**REQUEST**

Current Zoning: CG (general commercial) and MHP (manufactured home park)  
Proposed Zoning: N2-A(CD) (neighborhood 2-A, conditional)

Approximately 16.91 acres located on the west side of Old Statesville Road and north and south side of Ratcliff Lane, south of West W.T. Harris Boulevard.

The petition proposes the development of up to 198 triplex, quadraplex, and multi-family attached dwelling units. The site is currently developed with a manufactured home park and two single-family detached dwellings.

RZ-1

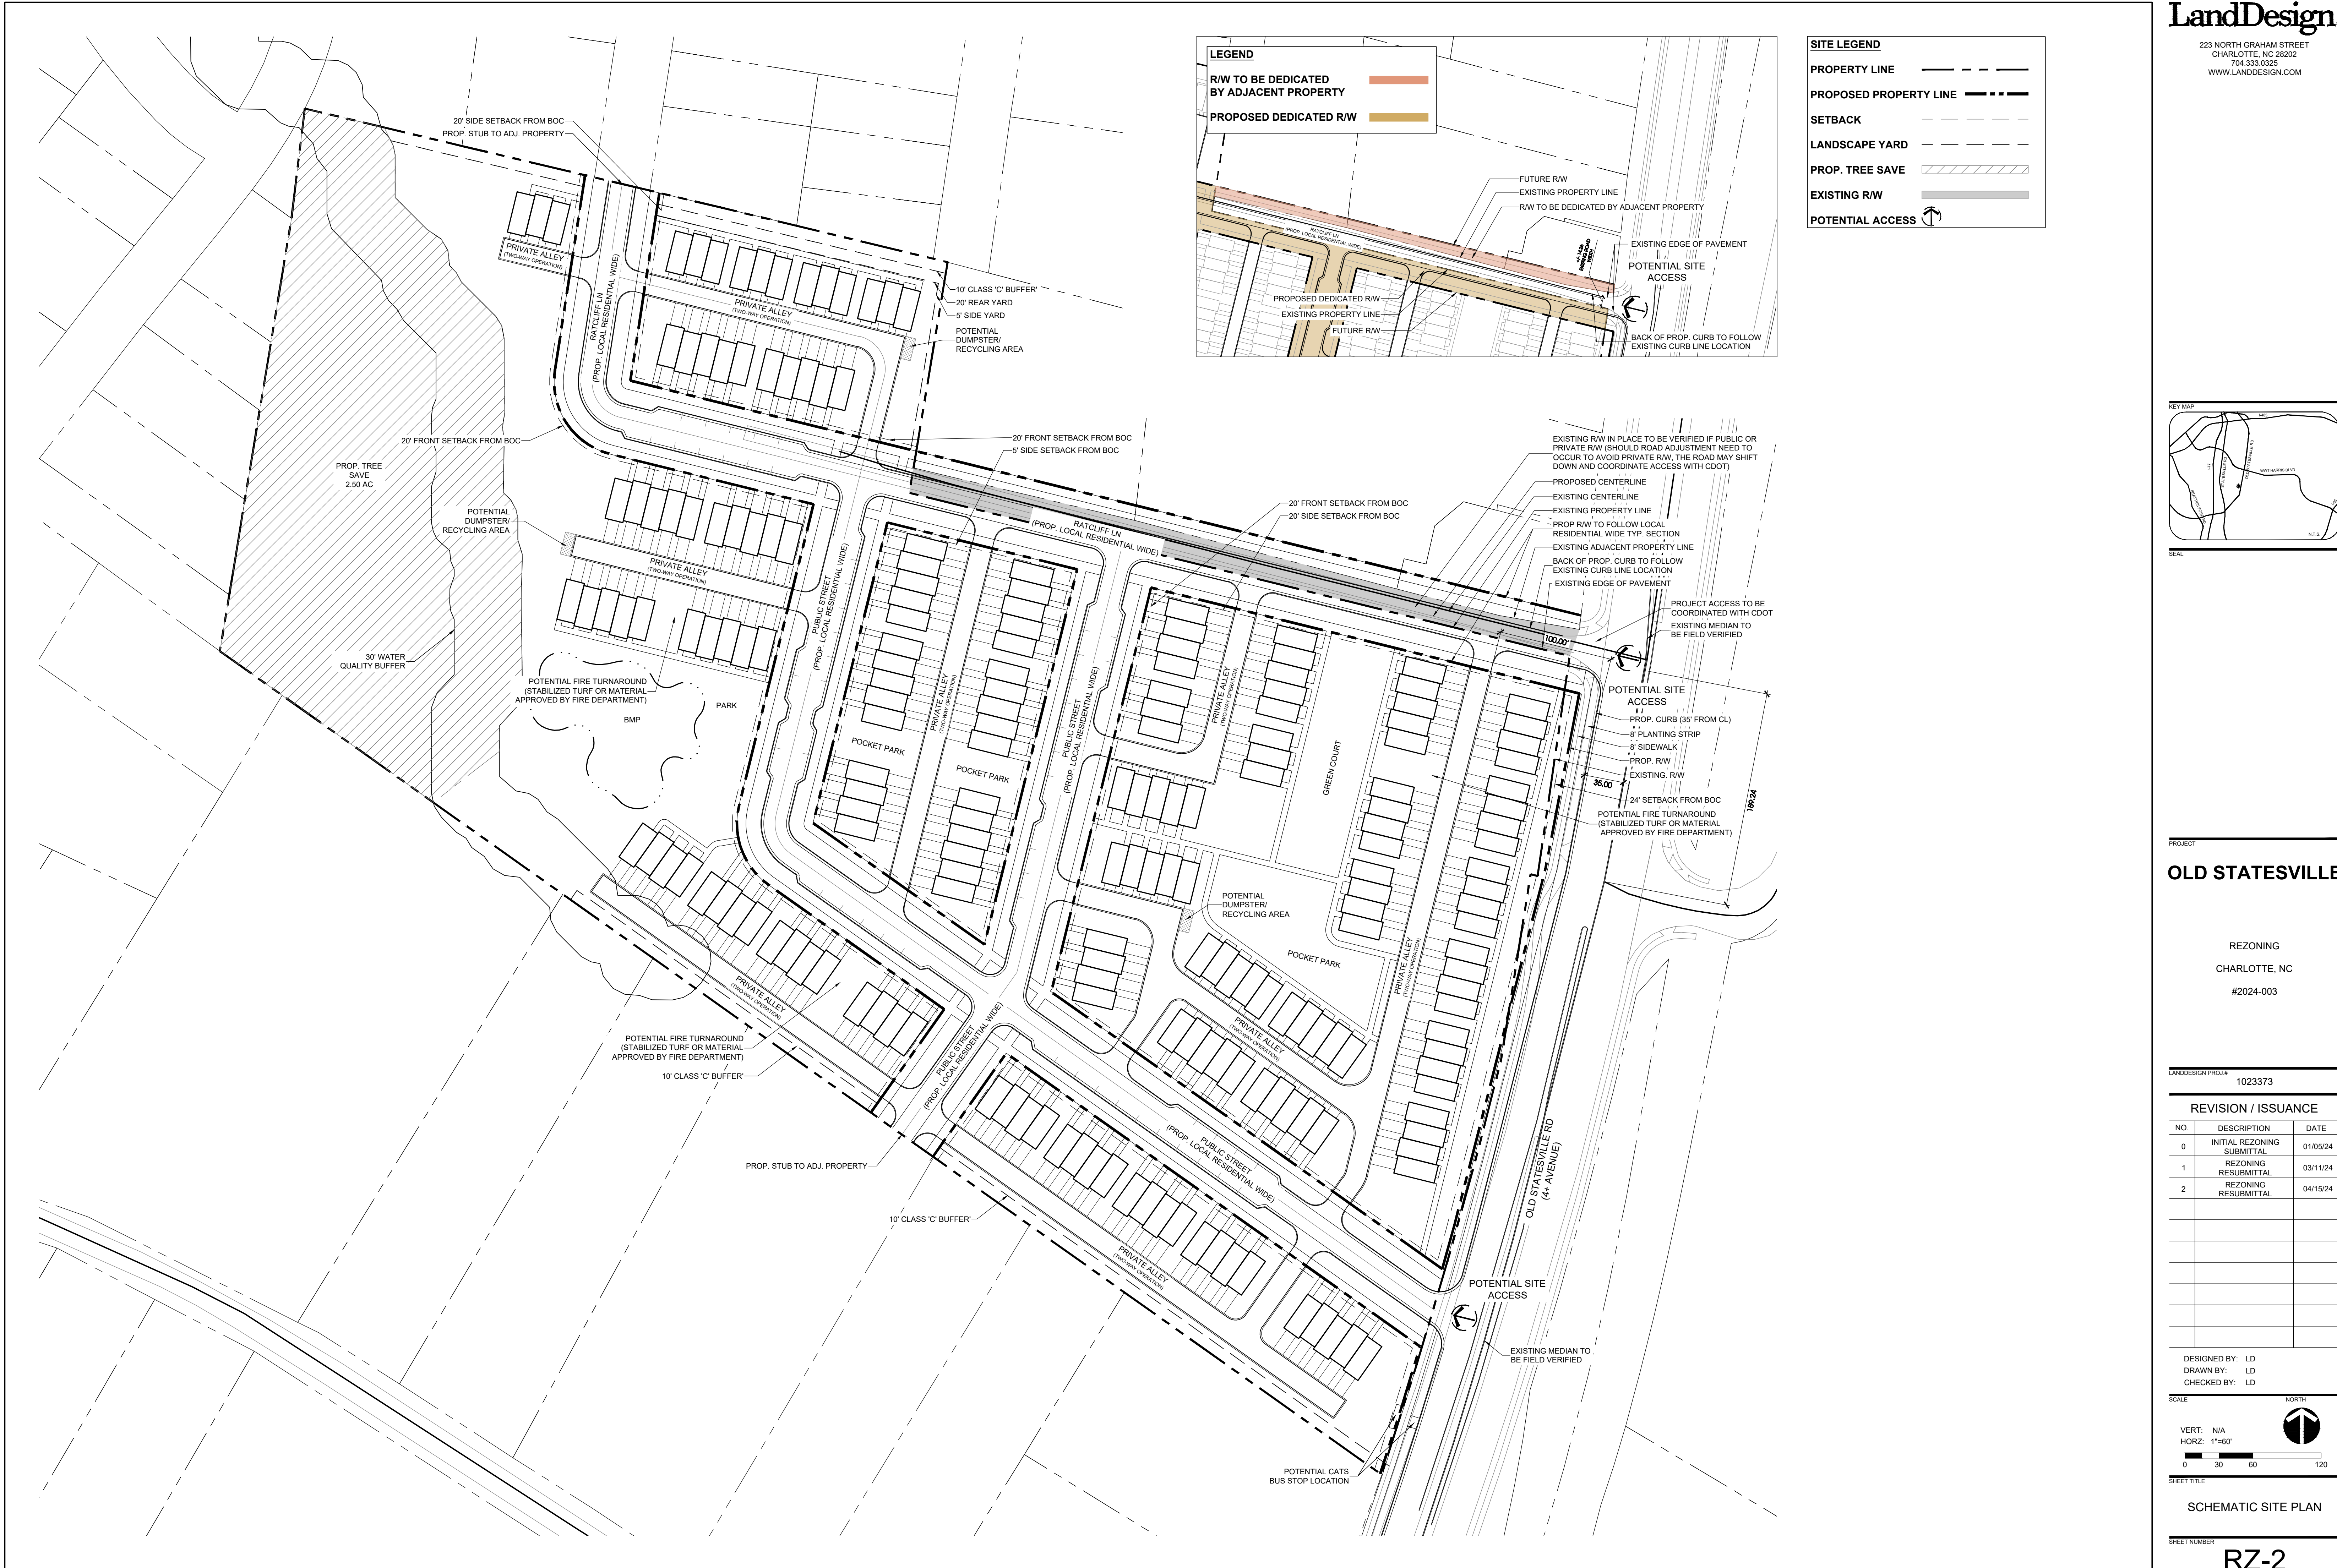
3. Plan sheet RZ-1 specifies a maximum dwelling count of 200 units while the rest of the plan specifies 198.

1. Ratcliff Lane: Location of future back of curb and gutter needs to be moved to 17.5 feet from the road centerline per Article 33 in the UDO. CLDSM standard U-03A2 Local Residential Wide Street. Label and dimension the curb and gutter from the centerline for each road on the site plan.
2. Add a conditional note specifying "All transportation improvements will be approved and constructed before the site's first building certificate of occupancy is issued." The petitioner may phase transportation improvements if said improvements and phasing are approved by CDOT and explicitly described in site plan notes.
